Planning Application BE/60/15/PL

Please accept this letter as notification of my objection to the above planning application in respect of 21 Bucksham Avenue, North Bersted for the following reasons:

Job.No:- 120096 Drg.No:- Rev:- 13

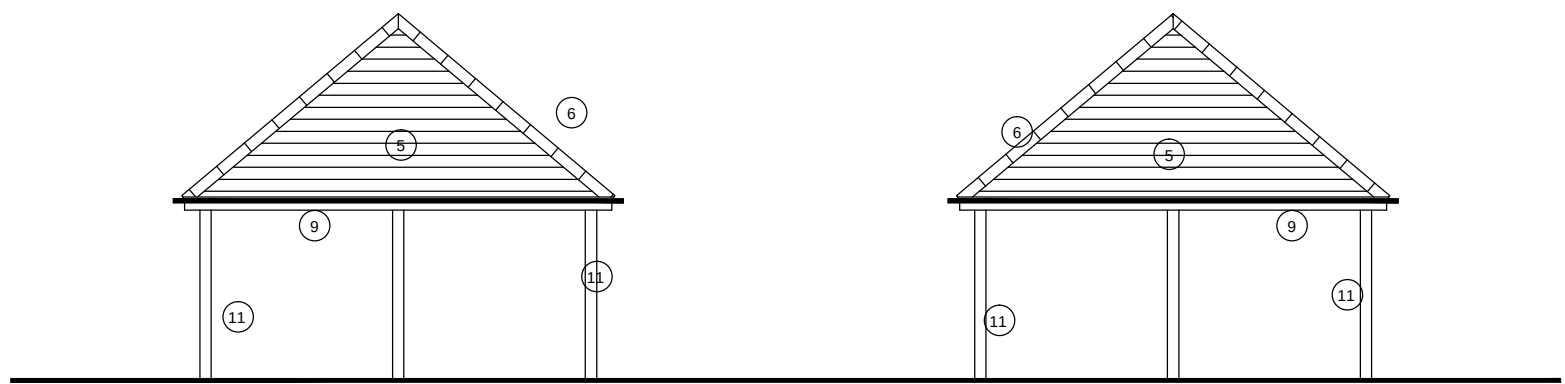
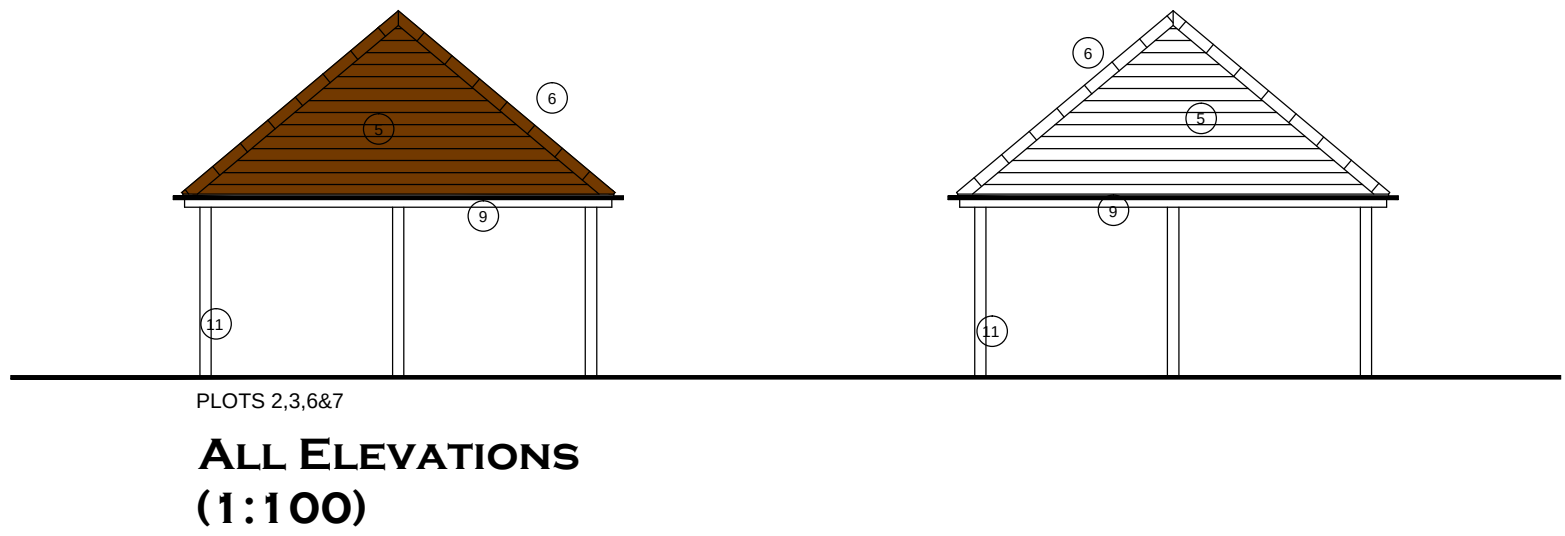
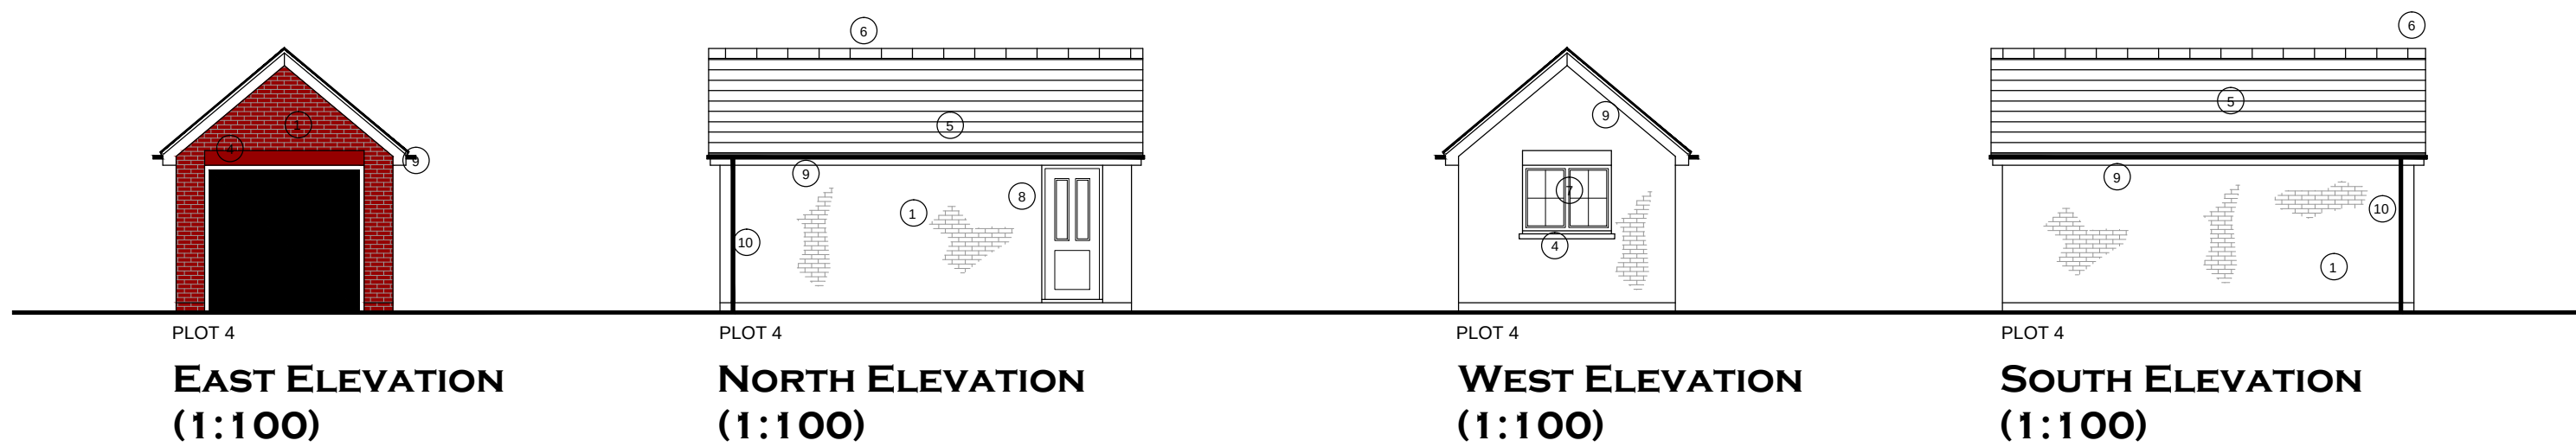
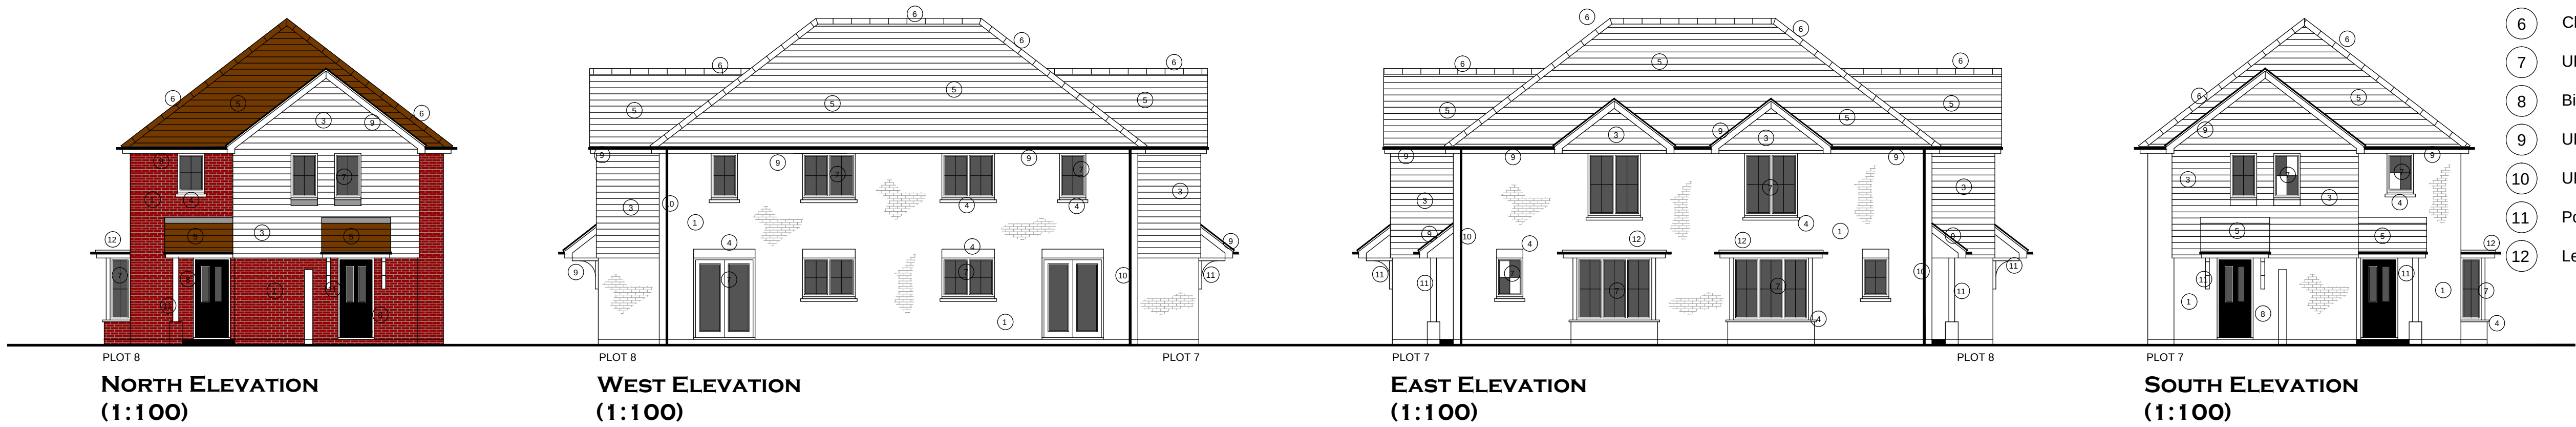
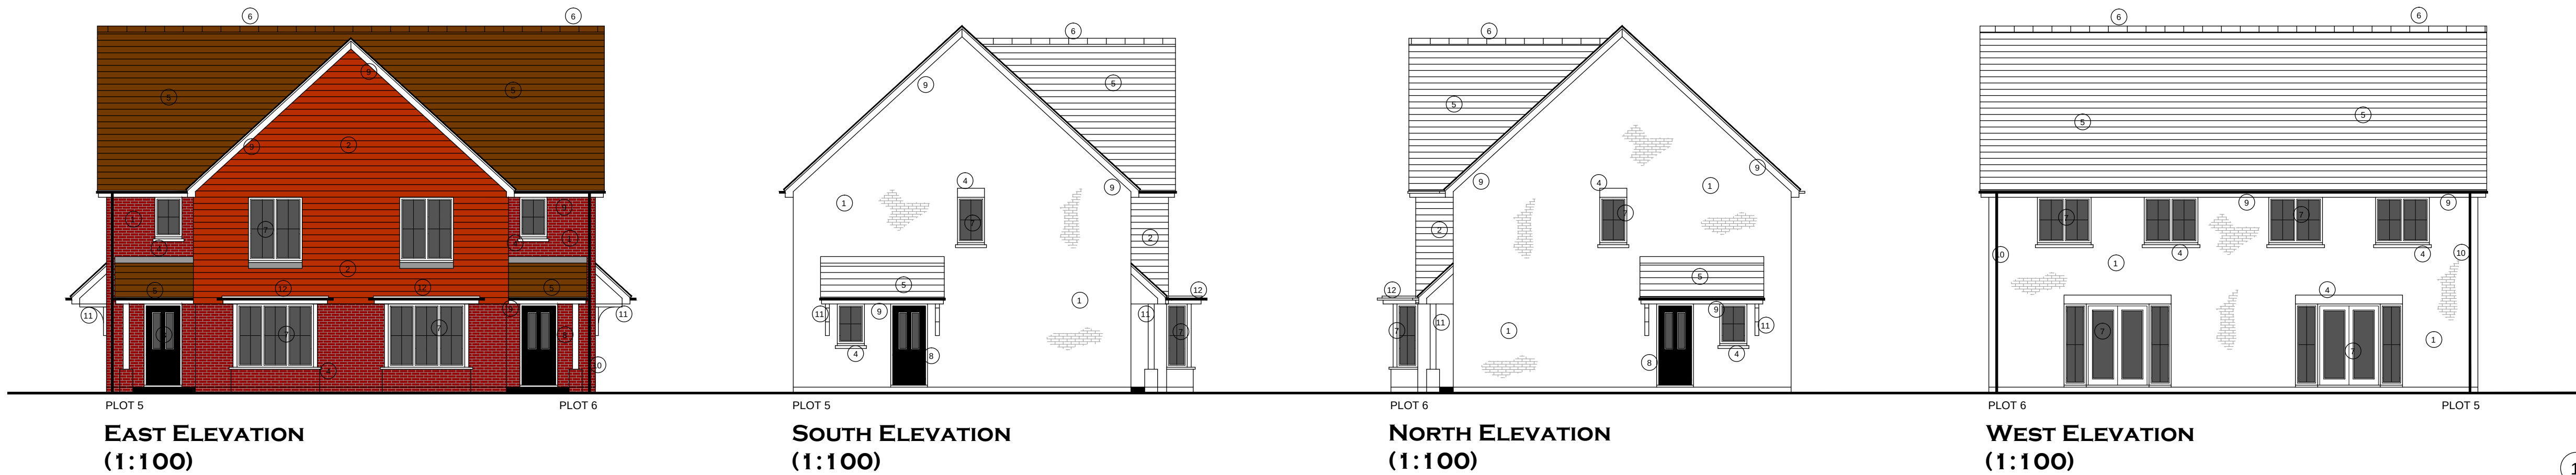
Units 6 & 7 and the garages to units 7 & 8 are situated on the BPNR ditch which is itself flood zone 3. Parts of units 6, 7, 8 and associated foot paths and driveways to 7 & 8 are on zone 2 flood risk. Recently downloaded flood risk map from the Environment Agency (**Appendix item 7**) clearly shows the proposed properties sited on this category of risk. Additionally, the EA flood risk map shown in the Bognor Regis Observer, December 19th 2013 (**Appendix item 8**) corroborates this stating that there is a 1 in 30 flood risk making this at the high end of the zone 3 flood risk spectrum. **Appendix Item 9** clearly demonstrates the extent of flood zone 3b & 2 on the proposals.

Units 6 & 7, and the garages to 7 & 8 clearly sit across the ditch which is in flood zone 3b. Therefore, the proposals clearly contradict the NPPF and its associated guidance in regard to flooding risk and should not be permitted. (see item 9).

- The first floor windows of units 1, 2, 3 look down and into the rear extension and garden of 426 Chichester Road which is a bungalow. As stated elsewhere, the houses are out of keeping with the street scene in Bucksham Avenue (by virtue of 30% of it being bungalows) and also out of keeping in respect of this property. This is contrary to Policy GEN 7 in respect of 426 Chichester Road for privacy, noise and disturbance.

- Within the site the proposed parking arrangements are unsatisfactory. If all three visitor bays are occupied then it is a physical impossibility for a vehicle in the central bay to exit without either striking one or both of the adjacent vehicles and/or the fence to unit 4 behind it. In the same way, a vehicle trying to leave the north parking bay could not do so with striking the centre bay vehicle and/or the fence to unit 4 or any vehicle parked in front of the garage to unit 5. This will lead to increased on street parking in Bucksham Avenue in or around the existing turning area to Bucksham Avenue or parking on the proposed road way adjacent to 17. This is further compounded by the fact that it is likely that many of the proposed units will have more than two vehicles in each household. This represents an increased safety risk to other road users, pedestrians and residents and result in unnecessary noise and disturbance and be un-neighbourly to the existing residents of the road and in particular the residents of 10,11,12,14,15,17.

- The national guidance requires that "*there should be vehicle access for a pump (i.e. Fire Appliance) to within 45metres of all points within a dwelling house*". This means the furthest habitable point at first floor level. As Fire Appliances cannot access the site units 1, 2, 3, 5, 6 all fail to comply with this requirement.

- The turning area provided within the site is also inadequate. A "pinch point" has been created between the garden to unit 4 and the southernmost visitor parking bay. A Fire Appliance requires a minimum 3.7 metre width so, not only would it be impossible for a Fire Appliance to access units 5 & 6, it also invalidates the turning area for Fire Service use for units 1, 2, 3 (NB:- a turning circle of 16.8 metres for Fire Appliances and 26.0 metres for ALPs or a hammerhead is required 20 metres from the end of an access road).
